Our reference: DOC13/17894;DOC13/17820; LIC07/2093-13  
Contact: Karen Marler 02 4908 6803

- 6 JUN 2013

**MODIFICATION TO MOUNT ARTHUR OPEN CUT COAL MINE  
ENVIRONMENTAL ASSESSMENT (09\_0062 MOD 1)**

I refer to your email of 24 April 2013 requesting comments and recommended conditions of approval from the Environment Protection Authority (EPA) for the above proposed project. I also refer to the document titled: *'Mt Arthur Coal Open Cut Modification Environmental Assessment'* prepared by Resource Strategies (undated) (the EA).

Figure 1.1: Site Location and Sensitive Receptors

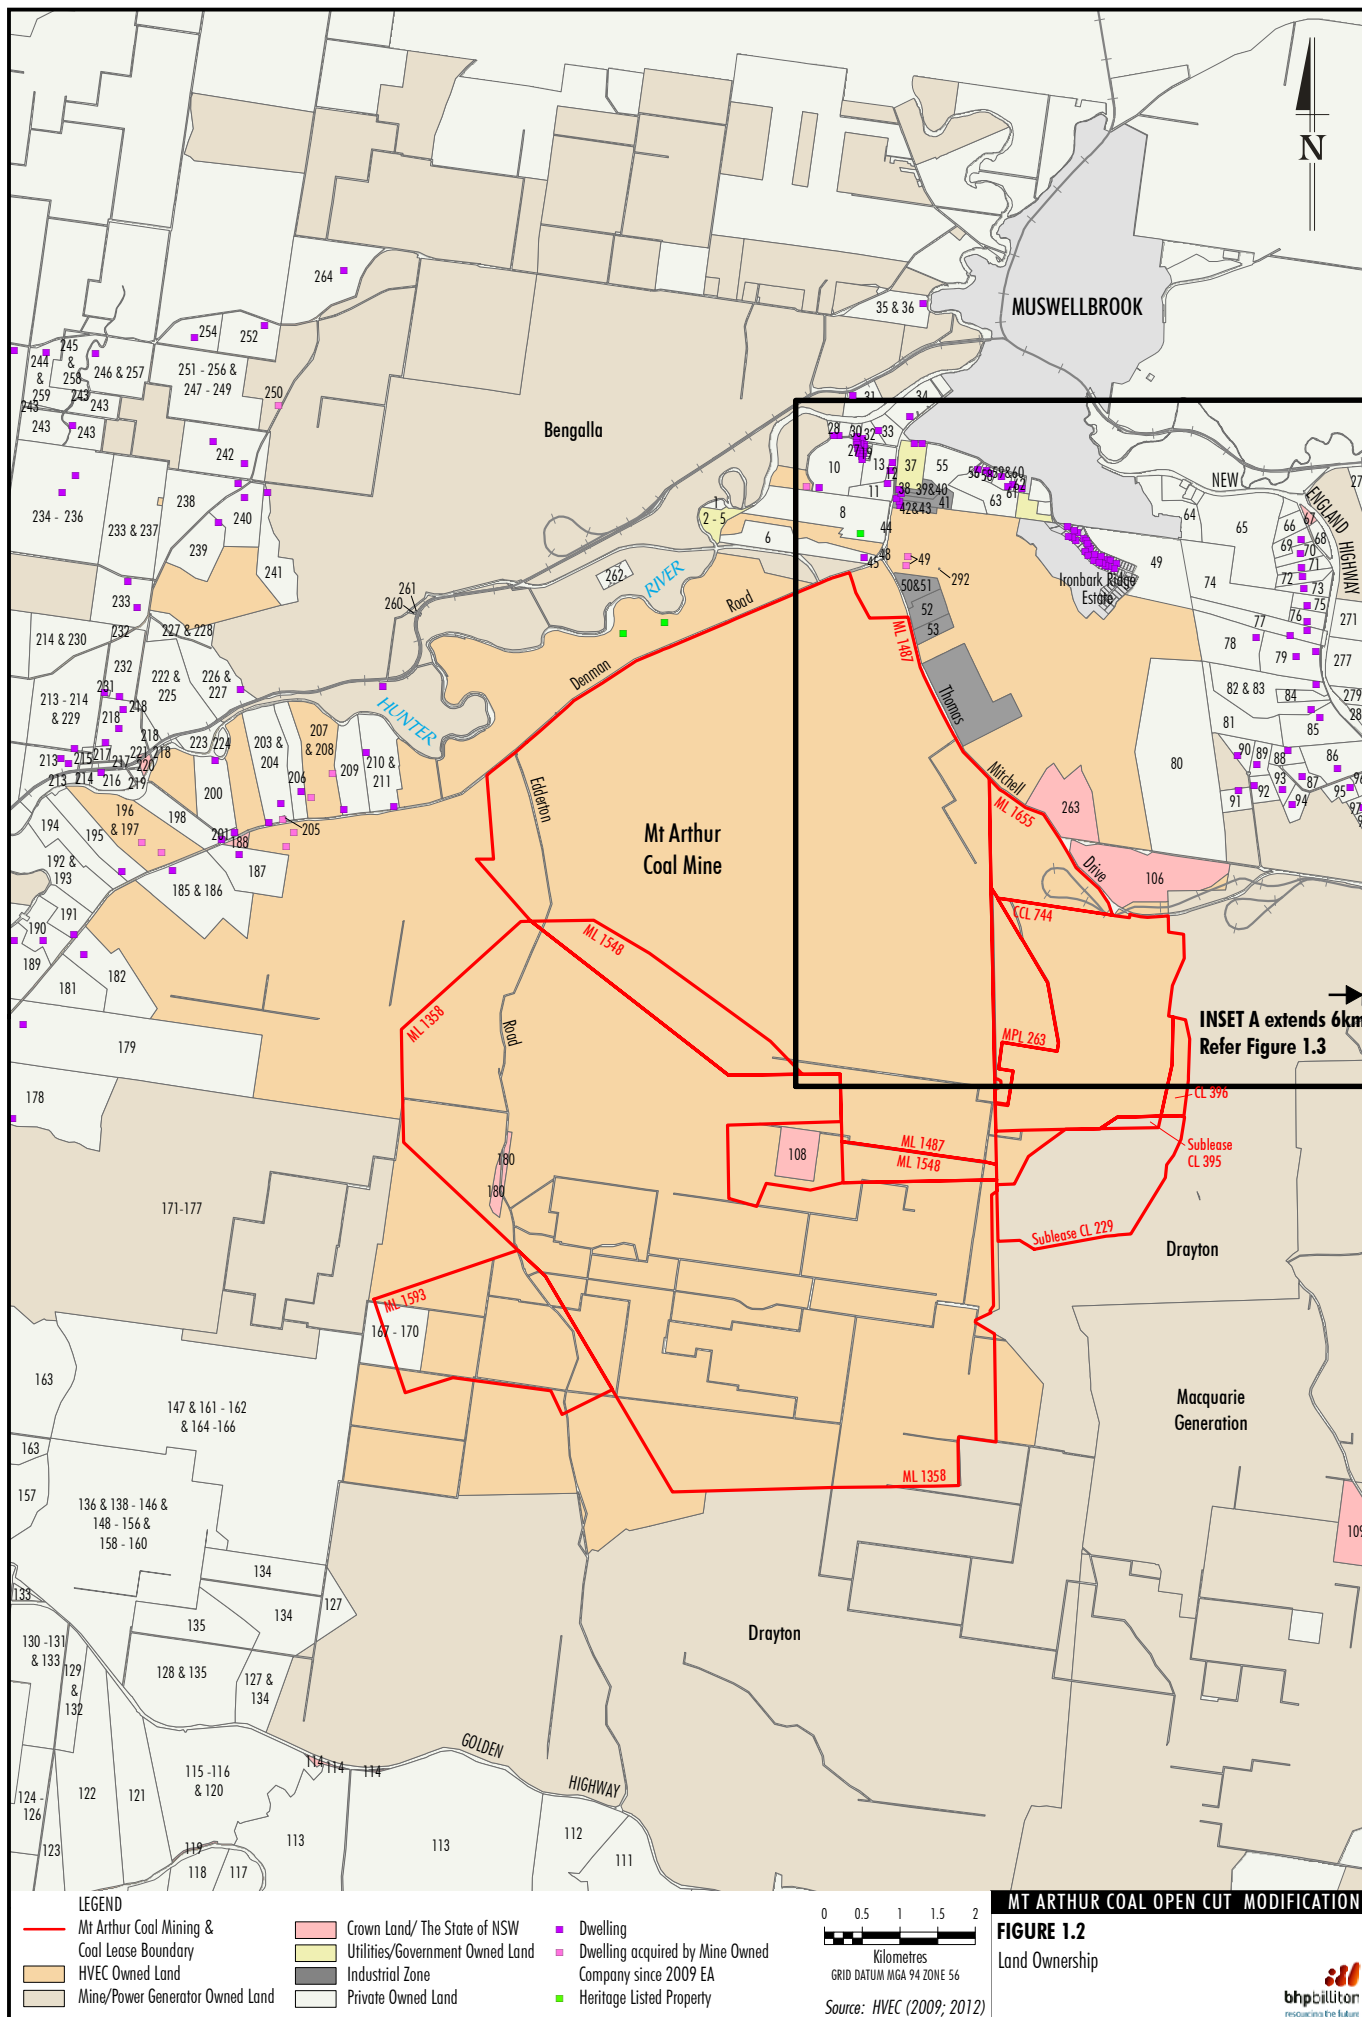
A cumulative 24 hour average  $\text{PM}_{10}$  impact assessment was undertaken at selected residences surrounding the Mt Arthur Coal Project. Exceedances of the EPA’s 24 hour average  $\text{PM}_{10}$  impact assessment criterion of 50  $\mu\text{g}/\text{m}^3$  are predicted at private receptors 187, 238, and 252 located to the north west of Mt Arthur Coal Mine. Exceedances are also predicted at private receptors within the existing Mt Arthur Coal Mine zone of acquisition (211, 226) and mine owned receptors (184a). A summary of exceedances identified in the AQIA is provided in table 1 below.

The predicted exceedances of the EPA’s cumulative 24 hour average  $\text{PM}_{10}$  impact assessment criterion of 50  $\mu\text{g}/\text{m}^3$  at the private receptors to the north west of the Mt Arthur Coal Mine indicates the potential for more wide spread exceedances at other private receptors to the north west of the site. Additionally, some issues were identified with the cumulative impact assessment methodology which could increase predicted concentrations at the private receptors to the north west of the site:

The locations of the six TEOM's for the proactive dust management system generally focus on Muswellbrook. There are two TEOM's in the vicinity of the private residences to the north west of the site where there is the potential risk of cumulative PM<sub>10</sub> impacts above the 24 hour average criteria. The EPA recommends that the locations of the TEOM's be reviewed to ensure they include the most potentially impacted private receptors to the north west of the site.
